Your ref:
Our ref: 22/01696/F
Please ask for: Luke Swales
Direct dial: 01553 616865
E-mail: borough.planning@west-norfolk.gov.uk

Details: **Proposed Two Storey Side Extension and Single Storey Rear Extension to 104.
at 104 West Street North Creake Fakenham Norfolk NR21 9LH**

I have received a planning application as detailed above but cannot process it until I receive some more information:

Section A-A - Client Proposal  
scale - 1:50

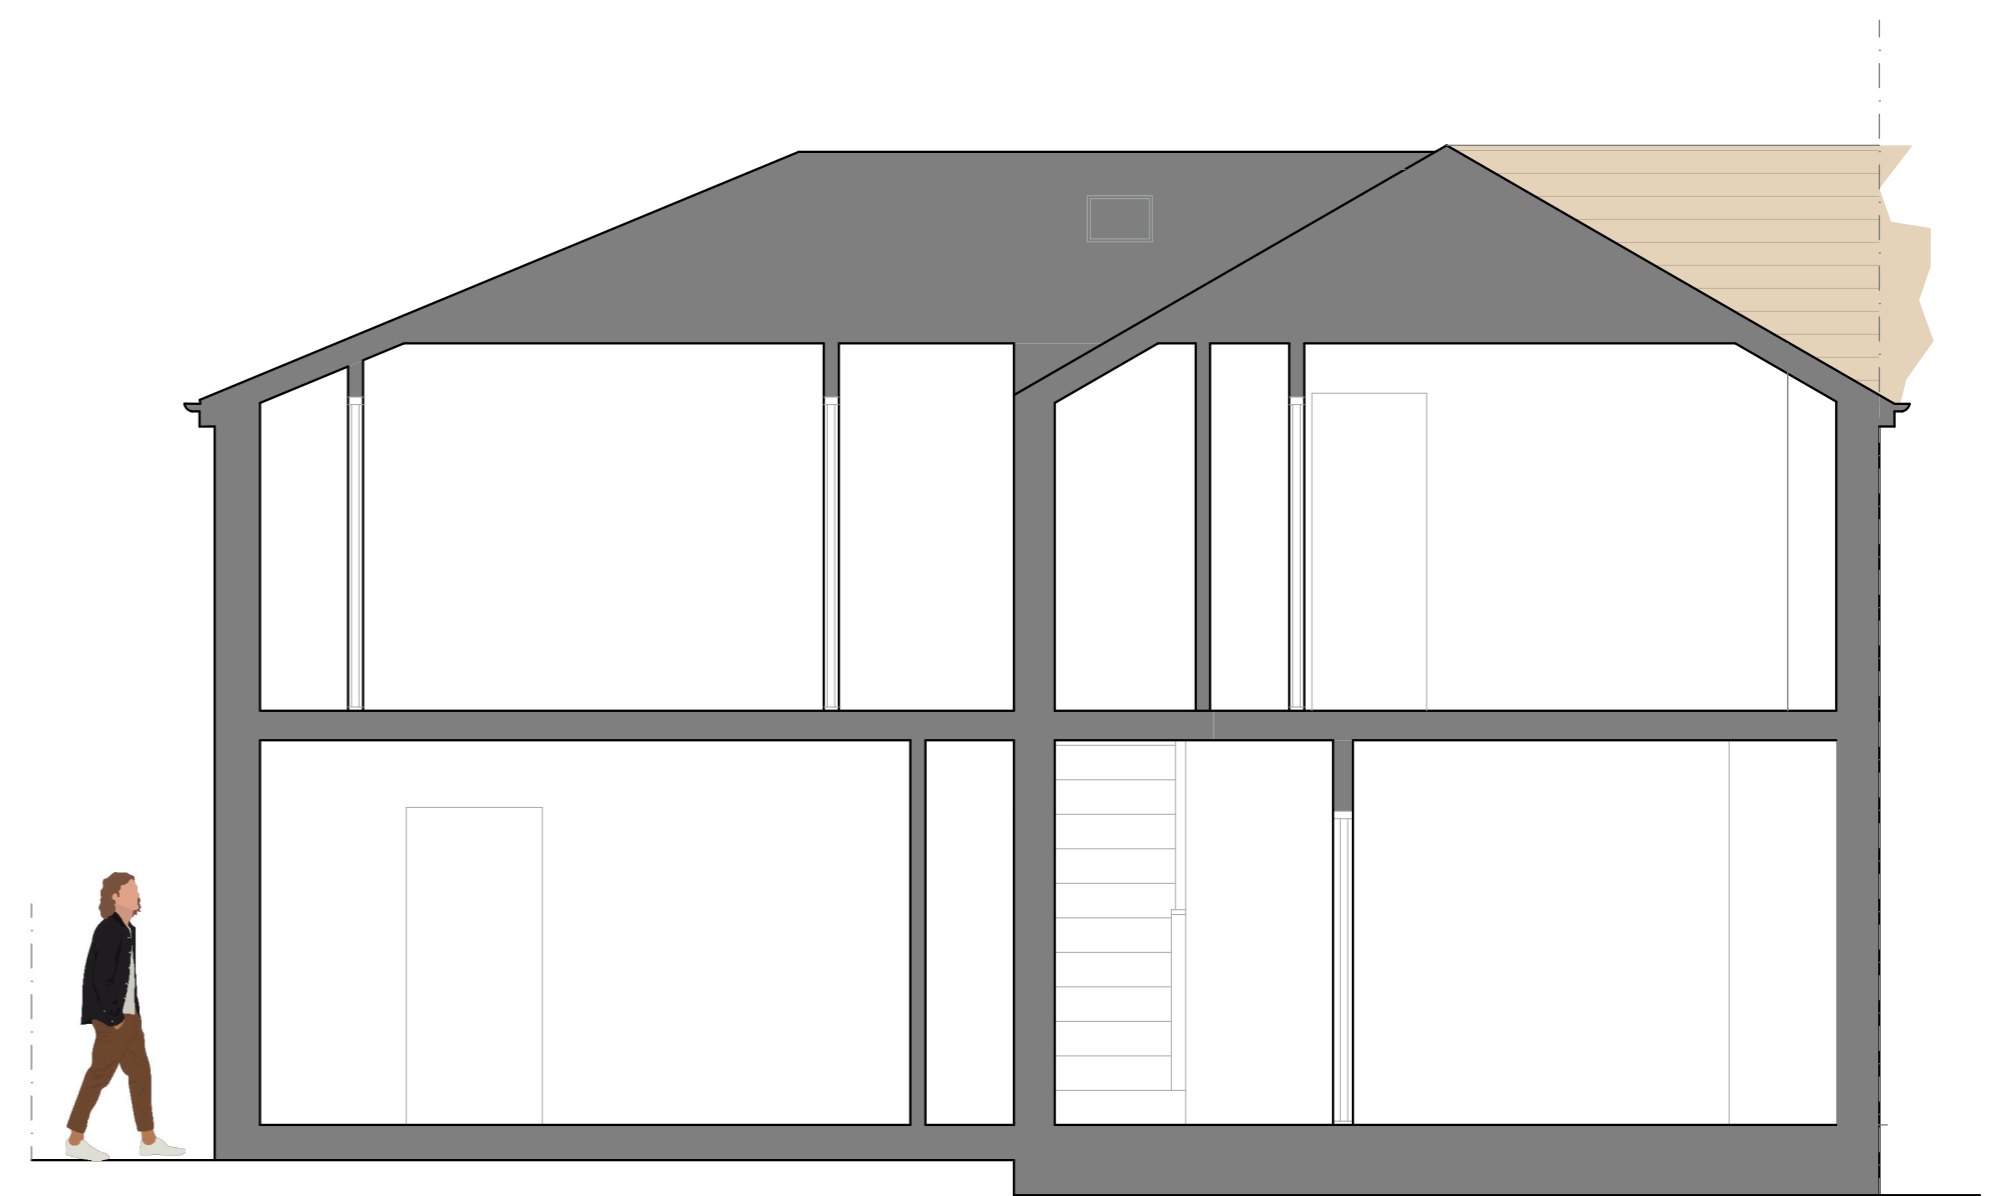
1. In accordance with the National Validation Checklist, which became mandatory on 6 May 2008, we will require information regarding site levels. If site levels are to change, please provide four copies of a site survey drawing, alternatively, if site levels are to remain unchanged, this can be annotated on the relevant plan or advised in writing.
2. On the submitted drawings 22.134.25 EX01 and 22.134.25 PL01, it appears that no roof plans have been submitted. As this is a householder application roof plans will be required. Please provide roof plans to a scale of either 1:50 or 1:100.
3. On the submitted drawings 22.134.25 EX01 and 22.134.25 PL01, it appears that no sections have been submitted. As the proposal is for a 2-storey extension, sections will be required showing finished floor levels and site levels.
